From: Sarah Burrow <Sarah.Burrow@arun.gov.uk>
Sent: 28 July 2021 14:40
To: Planning.Responses <Planning.Responses@arun.gov.uk>
Cc: Kathryn Welch <Kathryn.Welch@arun.gov.uk>; Paul Cann <Paul.Cann@arun.gov.uk>
Subject: RE: Planning Consultation on: CM/33/21/DOC

Engineers Comments Regarding Surface Water Drainage

Application No: CM/33/21/DOC
Registered: 29th June 2021
Site Address: Land at the Entrance to Waterford Gardens Horsemere Green Lane Climping BN17 5PQ
Description of Works: Approval of details reserved by condition imposed under ref CM/18/19/PL relating to Condition Nos 3 - materials & finishes, 4 - covered & secure cycle parking, 7 - surface water drainage and 8 - discharge flows to watercourses.

TITLE Proposed Site Layout Proposed Drainage			
SCALE 1:200		PROJECT No. 23078	
REPORT TYPE SB		DRG. No. 03 B

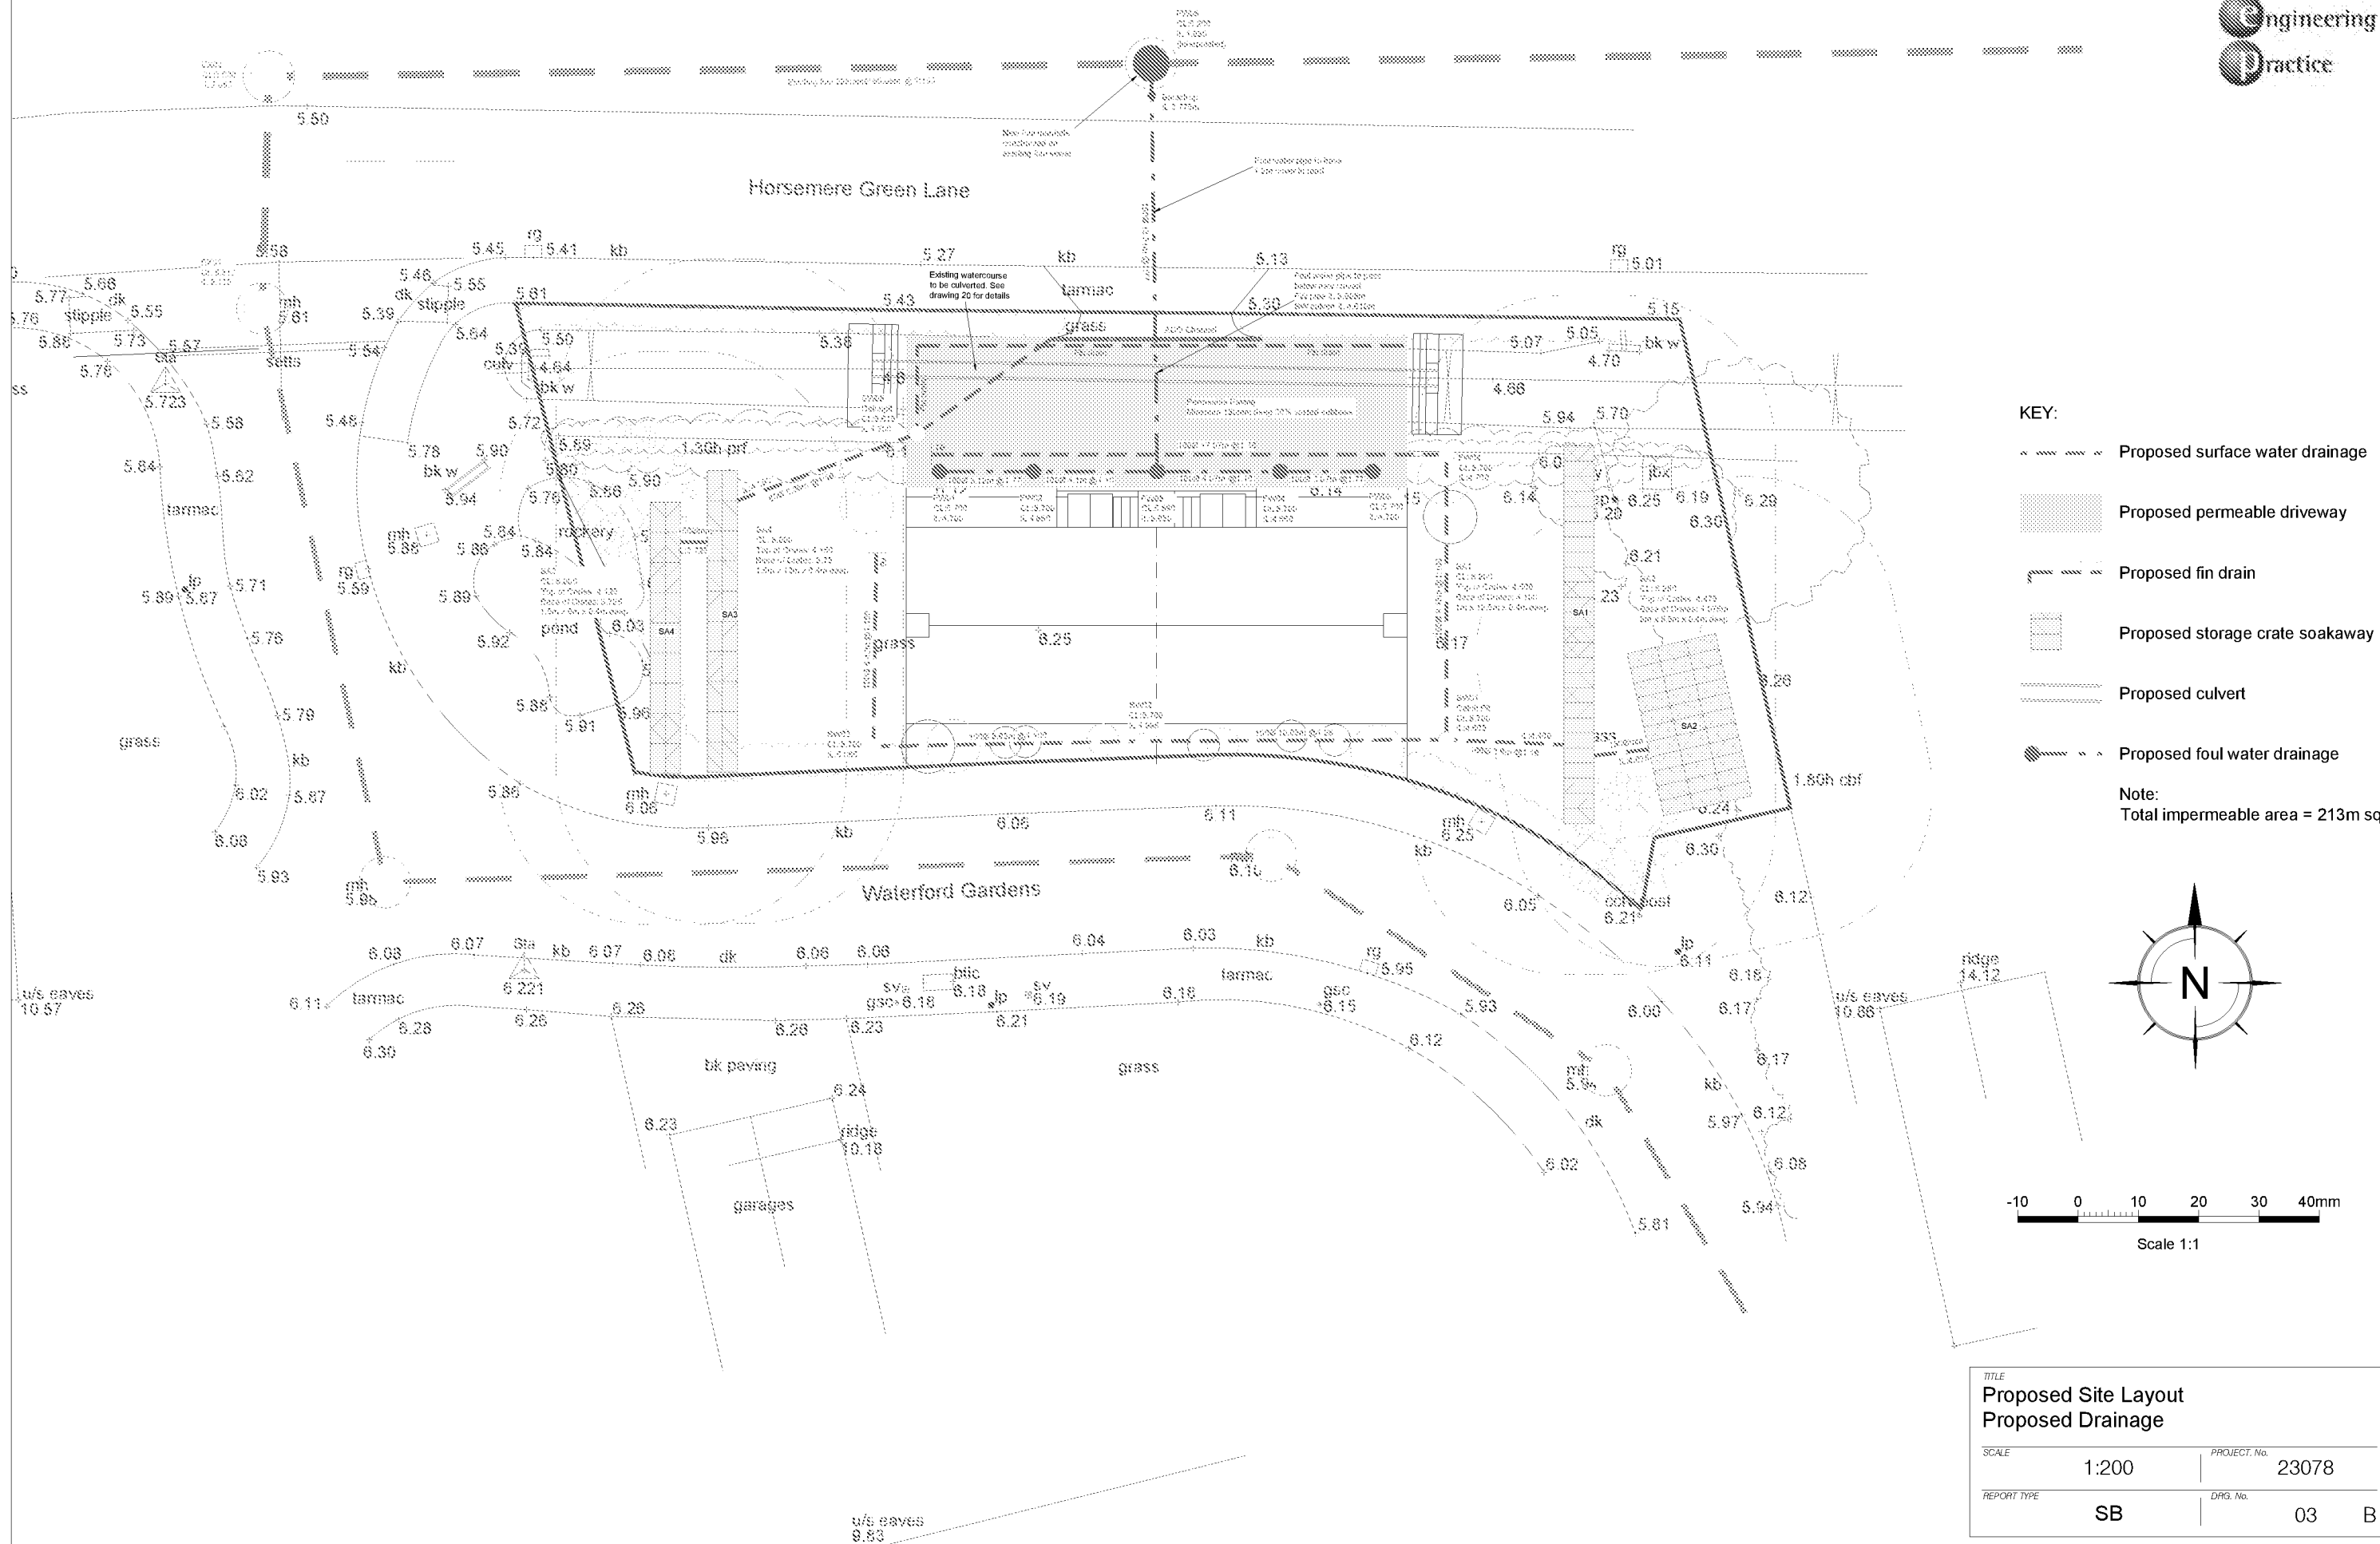
Given the slow infiltration rate (and half drain times) it is expected that an overflow will be required to the watercourse on the boundary. This will necessitate a redesign of the Drainage Layout and a new application for Ordinary Watercourse Land Drainage Consent. Please also include an allowance for urban creep in the updated calculations. The overflow to the watercourse from the soakaways should ideally be set above the 1 in 100 +40% depth to remove the need to rely on the overflow for most (if not all) events. The discharge rate and overflow level should be agreed with us before a further application is made.

Soakaways are set too deep, the infiltration tests indicated that infiltration was only viable at shallow depths (0.7mbgl) and yet SA1 is set at 2.1mbgl, SA2 at 2.175mbgl, SA3 at 2.275mbgl and SA4 at 2.25mbgl. The depths of all soakaways need to be raised to approximately 0.7mbgl, if this is unachievable please discuss and agree the

soakaway base level with us before a further application is made. In addition the soakaways are located within the tree root areas for two proposed semi-mature trees and one established tree. This is not acceptable. Soakaways should be located a minimum of 5m from the building and highways, and 2.5m from property boundaries.

Please ensure all pipes are a minimum of 100mm diameter.

In addition it seems the pond (which one property boundary appears to dissect) is being retained and a boundary of hedging is proposed directly over SA4. Again this is inappropriate. The infiltration test results clearly showed that infiltration was not viable in close proximity to the pond.
